COMMUNITY DEVELOPMENT DEPARTMENT
501 Delta Avenue ♦ Marysville, WA 98270 ♦ (360) 363-8000

Re: PA24-003 – Minor PRD – Technical Review 1

RE: Minor PRD, File# PA24-003
29 Lot Subdivision
8512 E Sunnyside Blvd & Parcel # 00590700017600

ROAD A ROAD SECTION

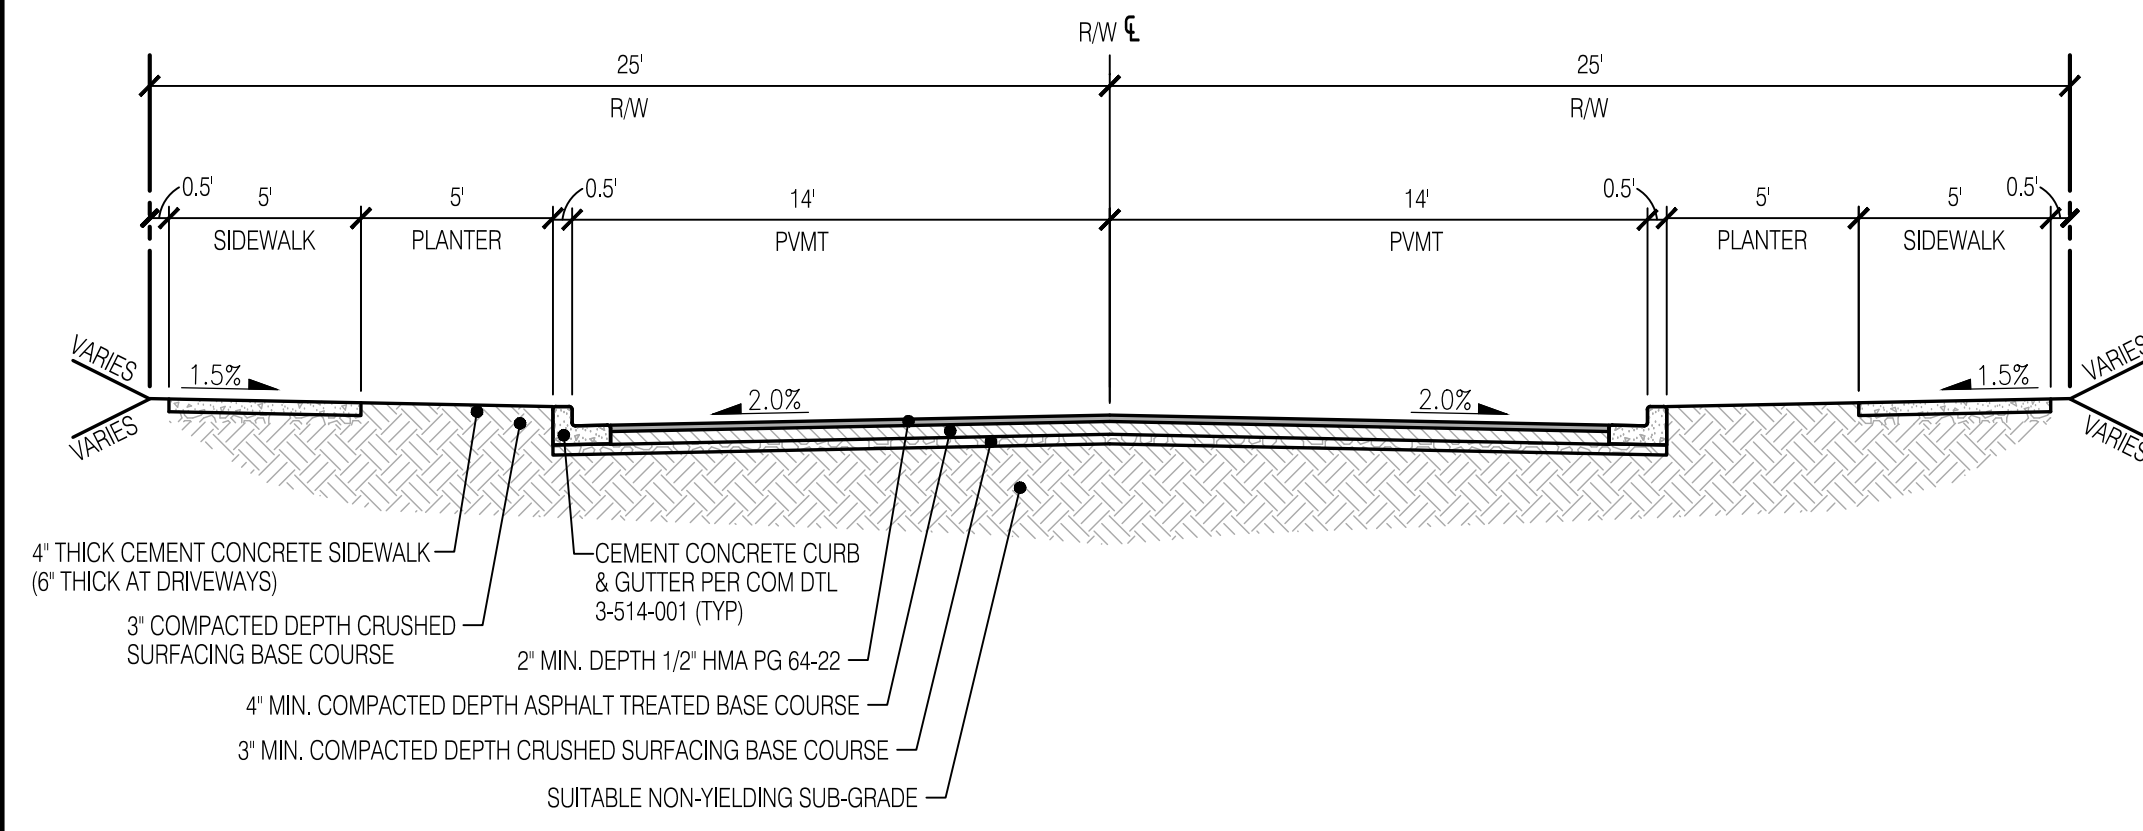
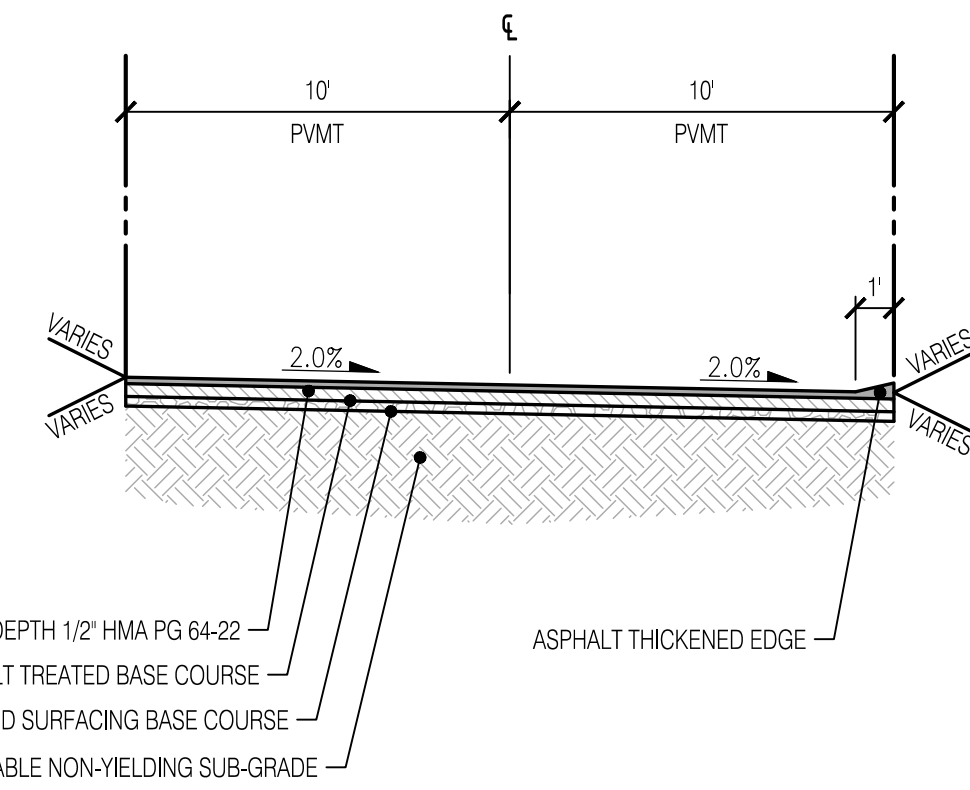
- a. No access shall be given to E Sunnyside Blvd, none is shown.
- b. The minimum width of a residential driveway is 12-feet and the maximum is 26-feet. Curb cuts shall be limited to a 20 foot maximum.
- c. The new roads shall be constructed to SP 3-202-002.

MINOR PROPERTY BINDING SITE PLAN

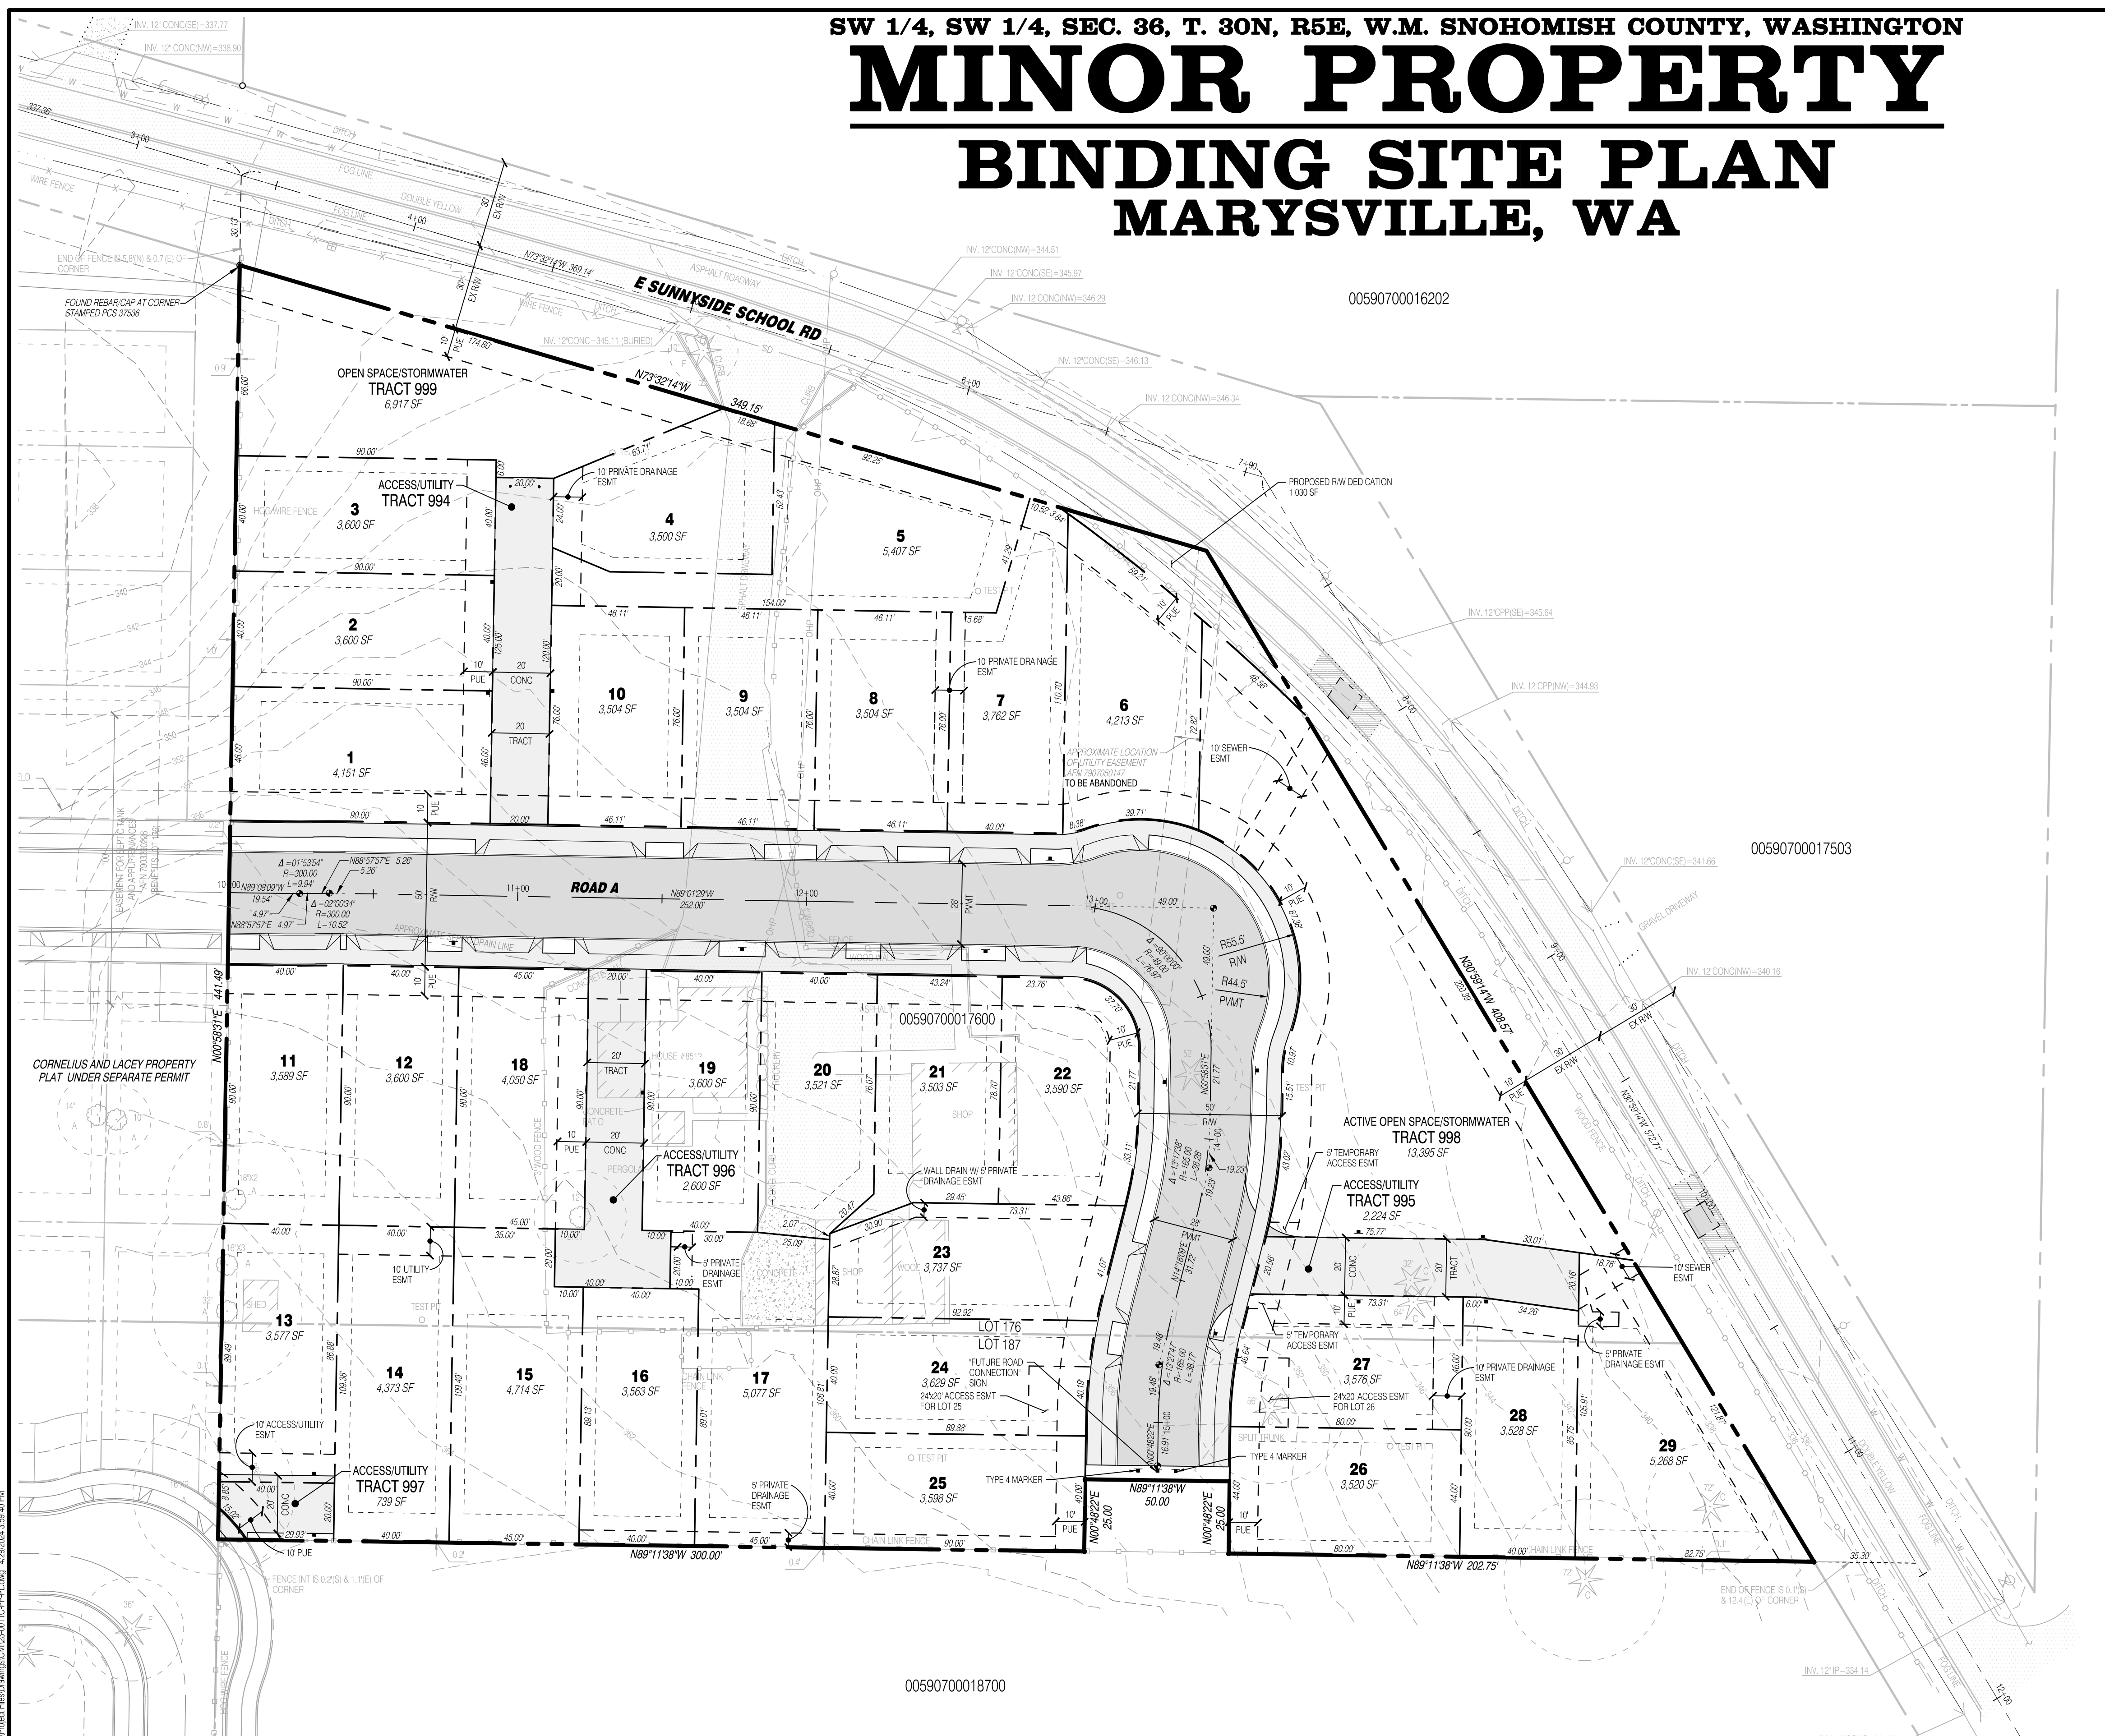
7. Building setbacks shall be measured from the edge of the temporary cul-de-sac. Please revise setbacks on lots 23, 24 and 26 accordingly.

7.1. The setback/building envelope on lot 24 shall reflect the access easement for lot 25.
